From: Laura Gibbons <Laura.Gibbons@arun.gov.uk>
Sent: 08 March 2022 12:05
To: Planning.Responses <Planning.Responses@arun.gov.uk>
Cc: Simon Davis <Simon.Davis@arun.gov.uk>
Subject: RE: Planning Consultation on: Y/24/22/DOC

Engineers Comments Regarding Condition 23

Application No: Y/24/22/DOC
Registered: 18th February 2022
Site Address: Cinders Nusery & land r/o Cinders Lane Yapton BN18 0JJ
Description of Works: Approval of details reserved by condition imposed under ref Y/24/22/DOC relating to Condition Nos:2 3: SUDs management manual and 24 - SUDs As Built Drawings

Figure 10: Snip of As Built Showing Proposed Position of the Geocellular Attenuation Crates

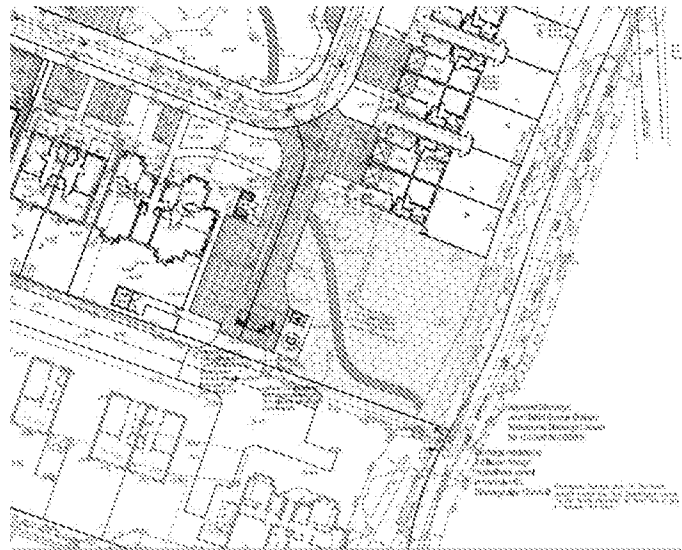
5. The report acknowledges that it was not possible to verify the size of attenuation crates installed on site, this is inadequate. Please provide as built survey, and commentary upon whether this is consistent with design.

Figure 15: Snip of Missing Gully on As Built Drawing

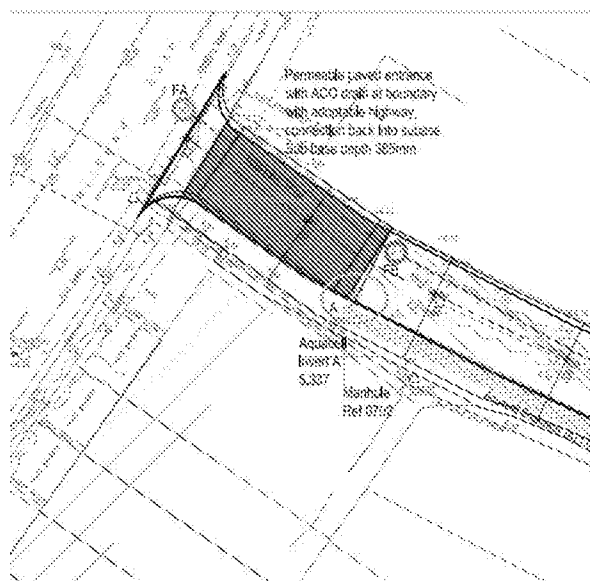
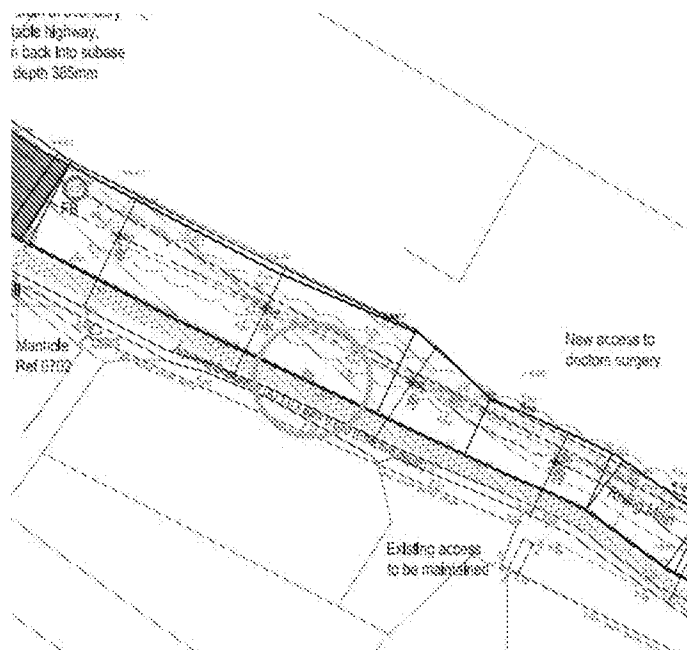
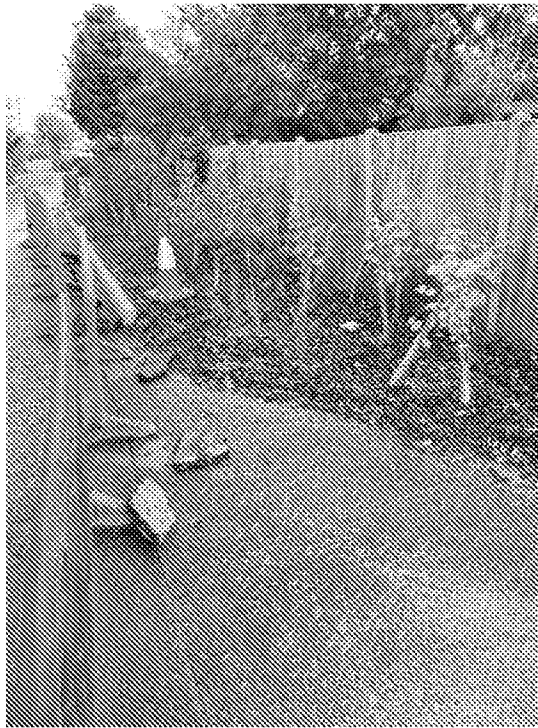
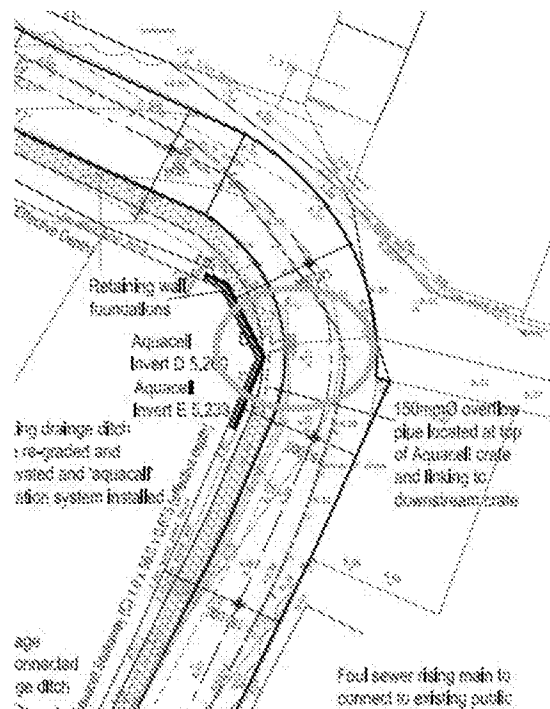
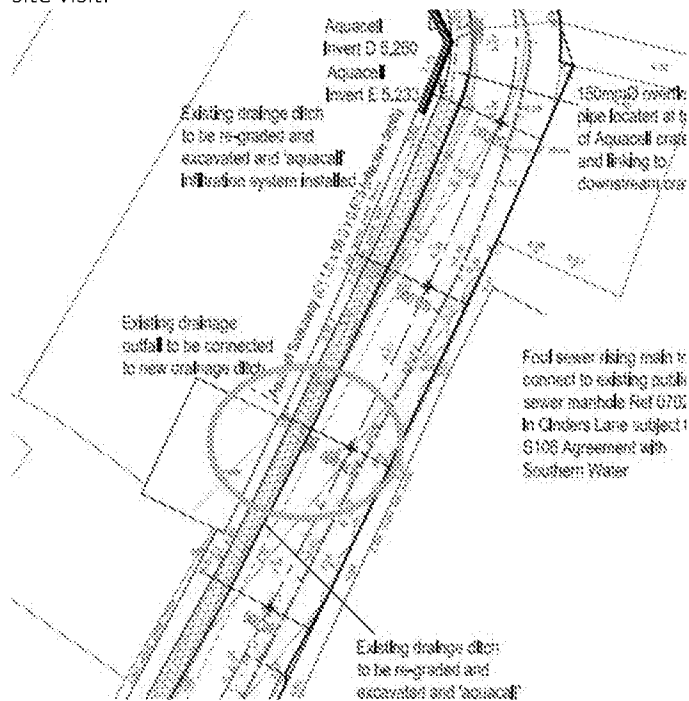
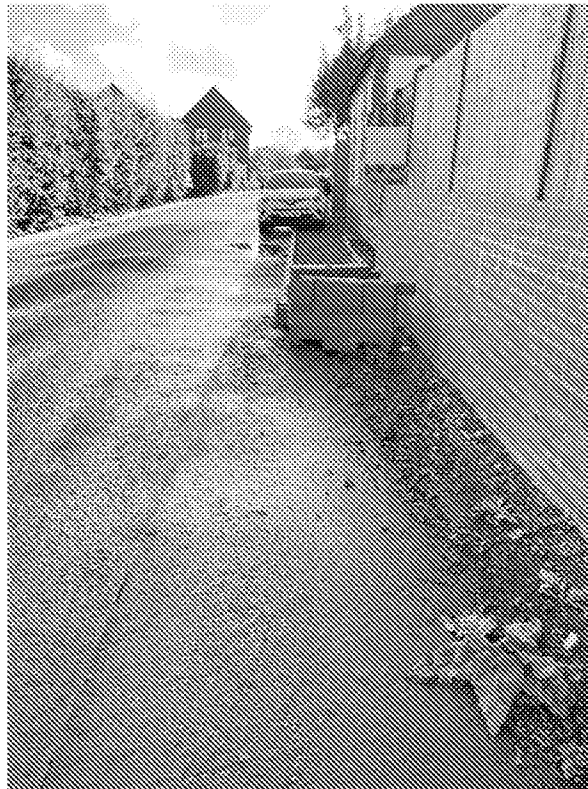
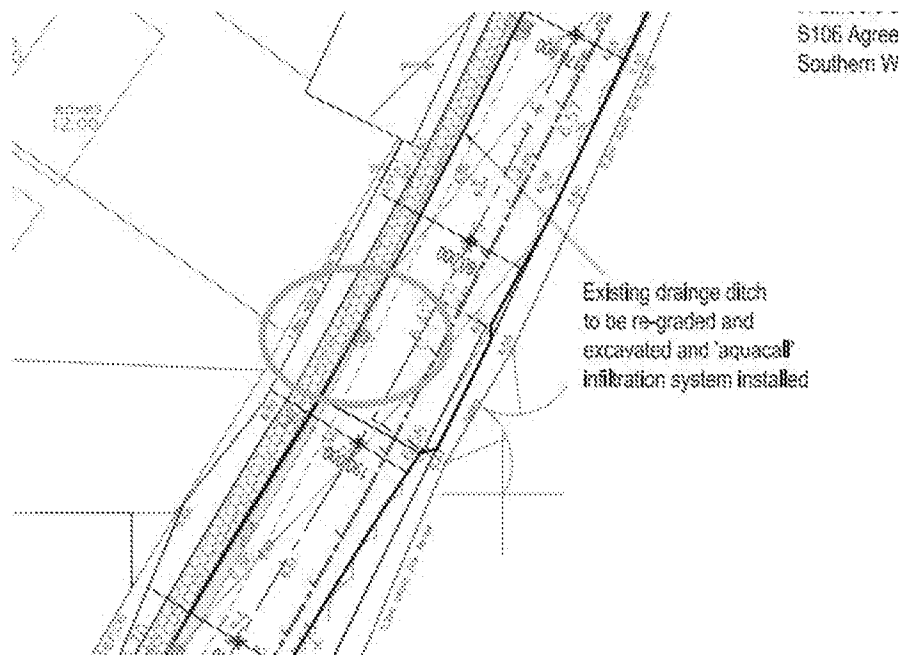
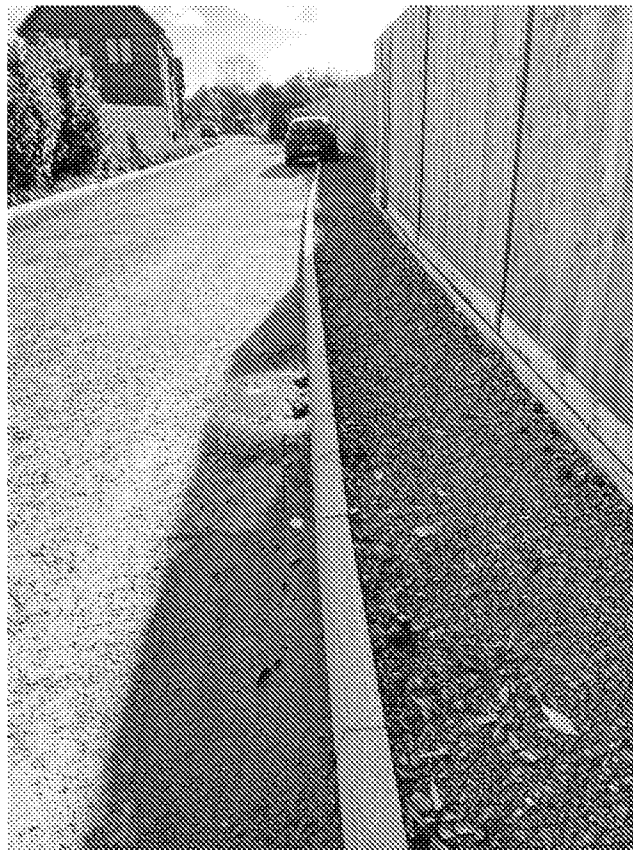
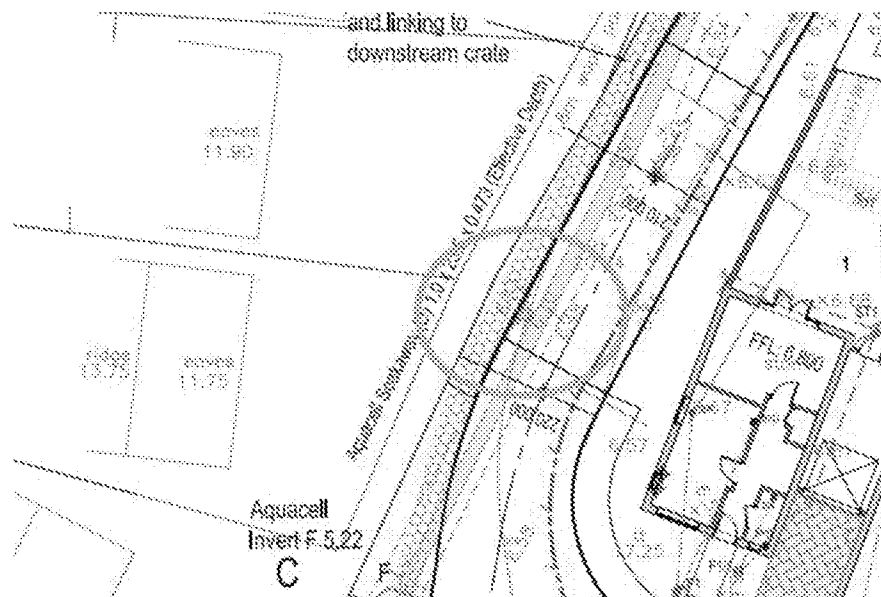
6. Gullies A-F were noted to not be present during the site visit. "Remedial works evidence" has been supplied in the form of photos showing "stoned up excavation" at each gully location. This is not evidence of gullies having been installed and appropriately connected. Please provide evidence showing all missing gullies in situ and details of inspections and survey of the connections from these.
